From
The Member Secretary,
Madras Metropolitan
Development Authority,
Thalamuthu-Natarajan Building,
No.8, Gandhi Irwin Road,
MADRAS: 600 008

Lr.No. A2/10691/90 dated 07.90.

Sub: MMDA - Planning permission - ^{Additional} Construction
of Residential/
building in Plot No. 30, ^{Defence officers colony} at S.No. 166 of
^{Nandambakkam} village - Approval of - Reg.

SITE PLAN
(SCALE: 1"=20'-0")

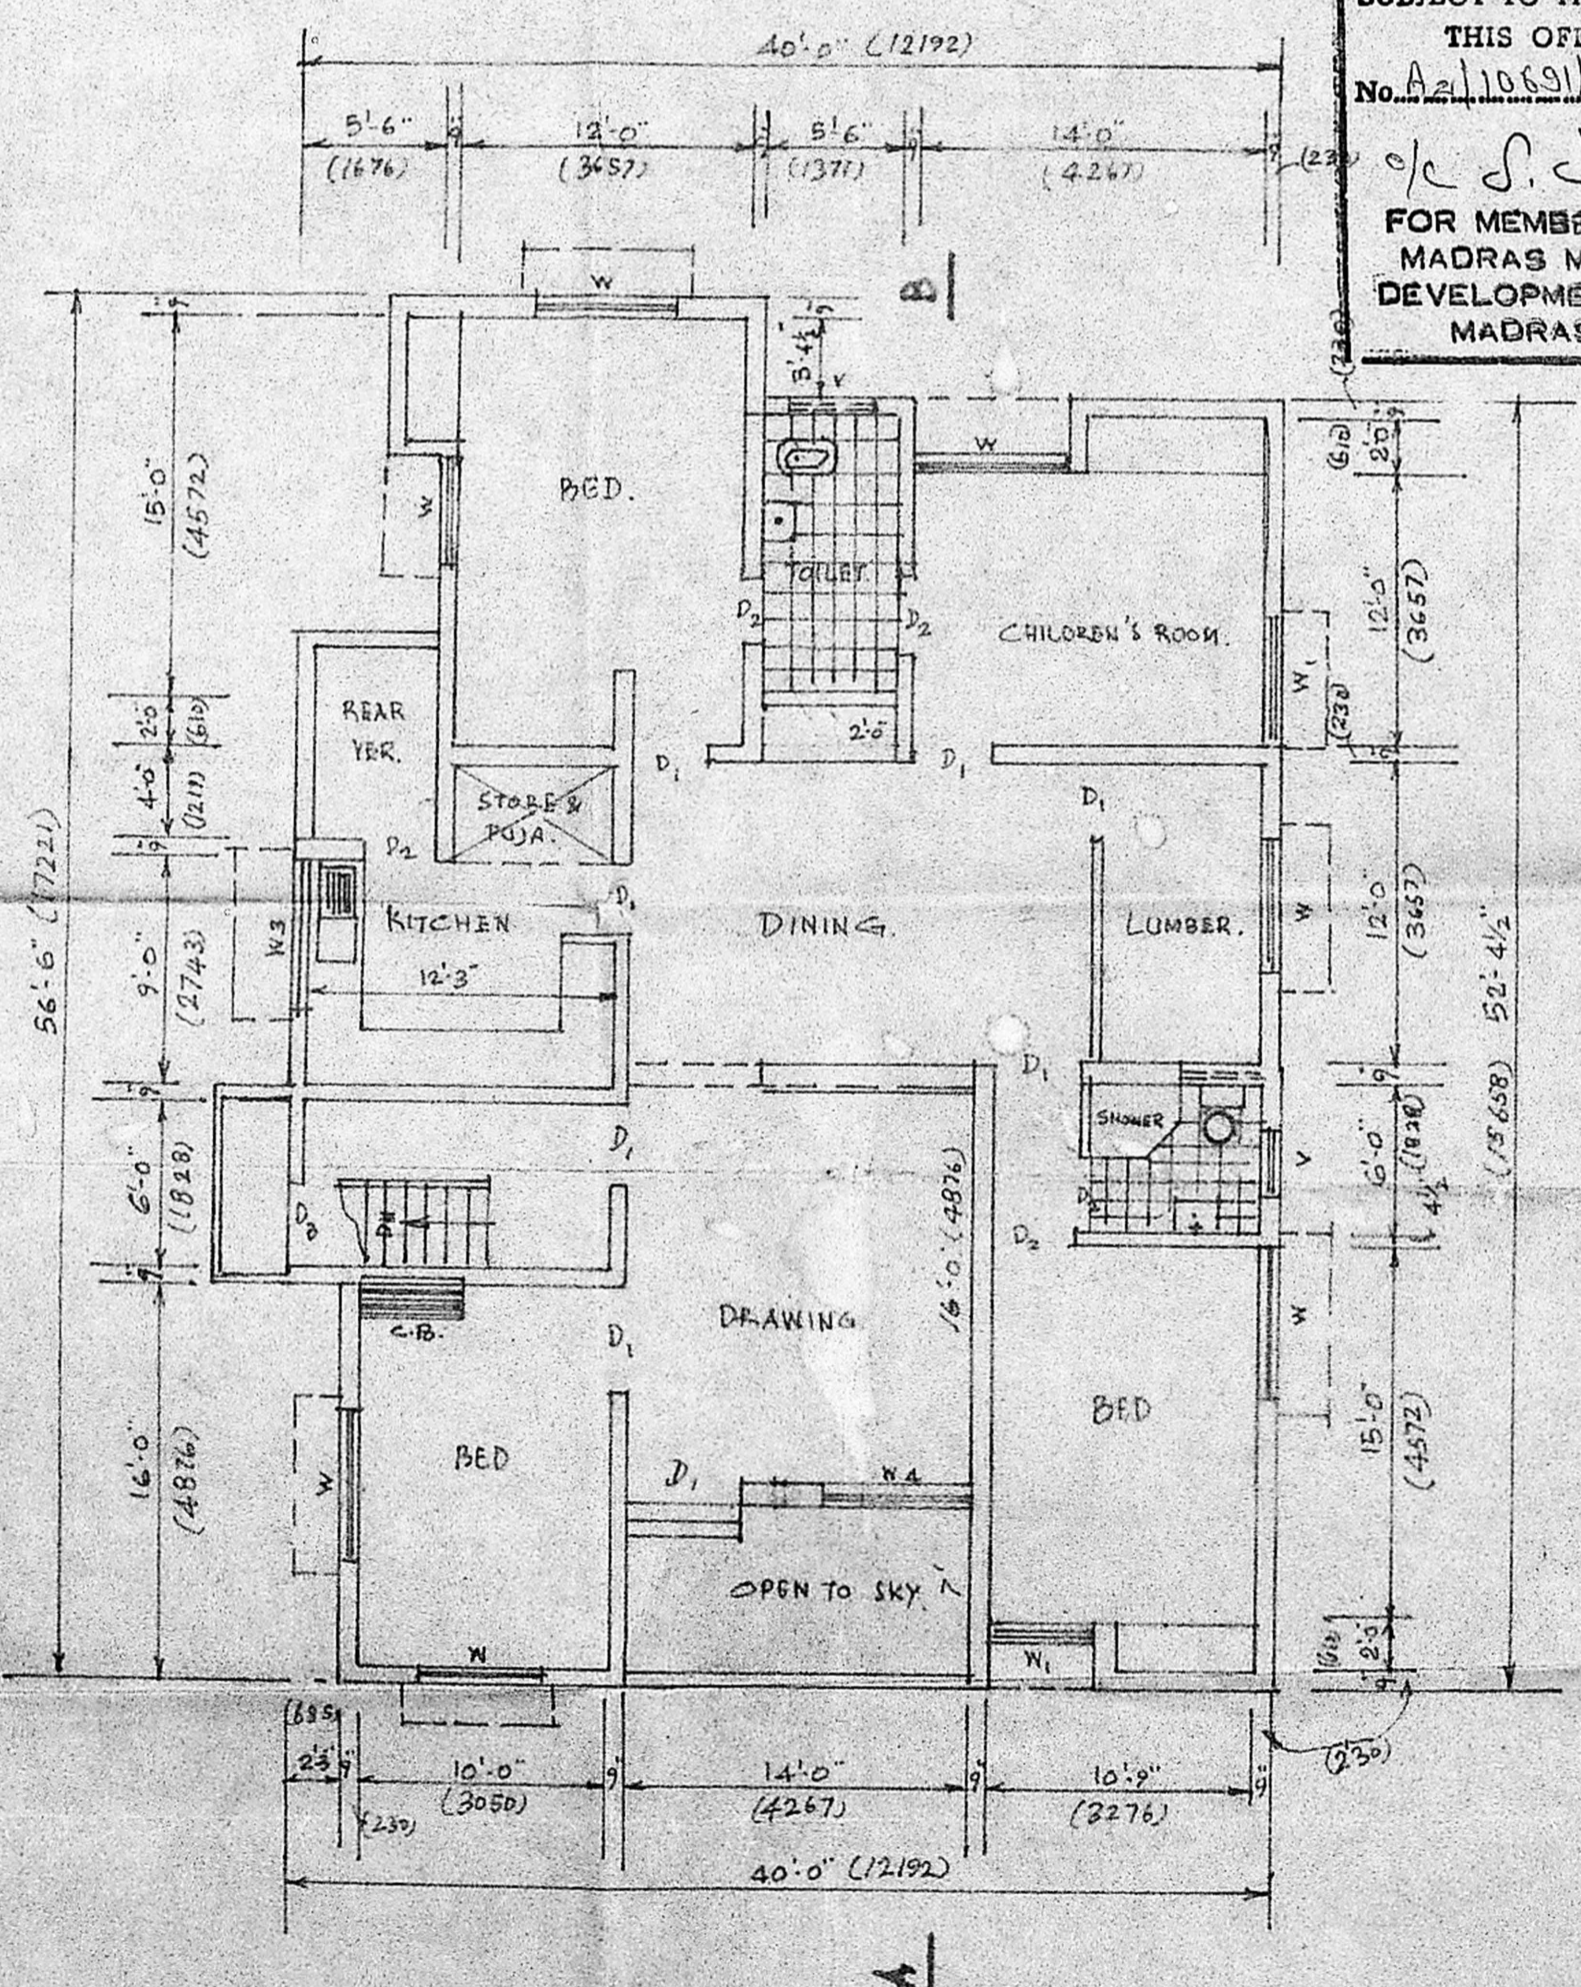
The proposal received in the reference cited for the ^{additional} construction of Residential/
building at Plot No. 30 ^{Defence officers colony} Survey No. 166 of Nandambakkam village has been examined and you were requested to submit the revised plans to satisfying rules. The revised plans submitted by you directly to this office was examined and found approvable. ^{and also you are requested to furnish the Revised plan showing the play requirement of 4.5m x 4.5m area}
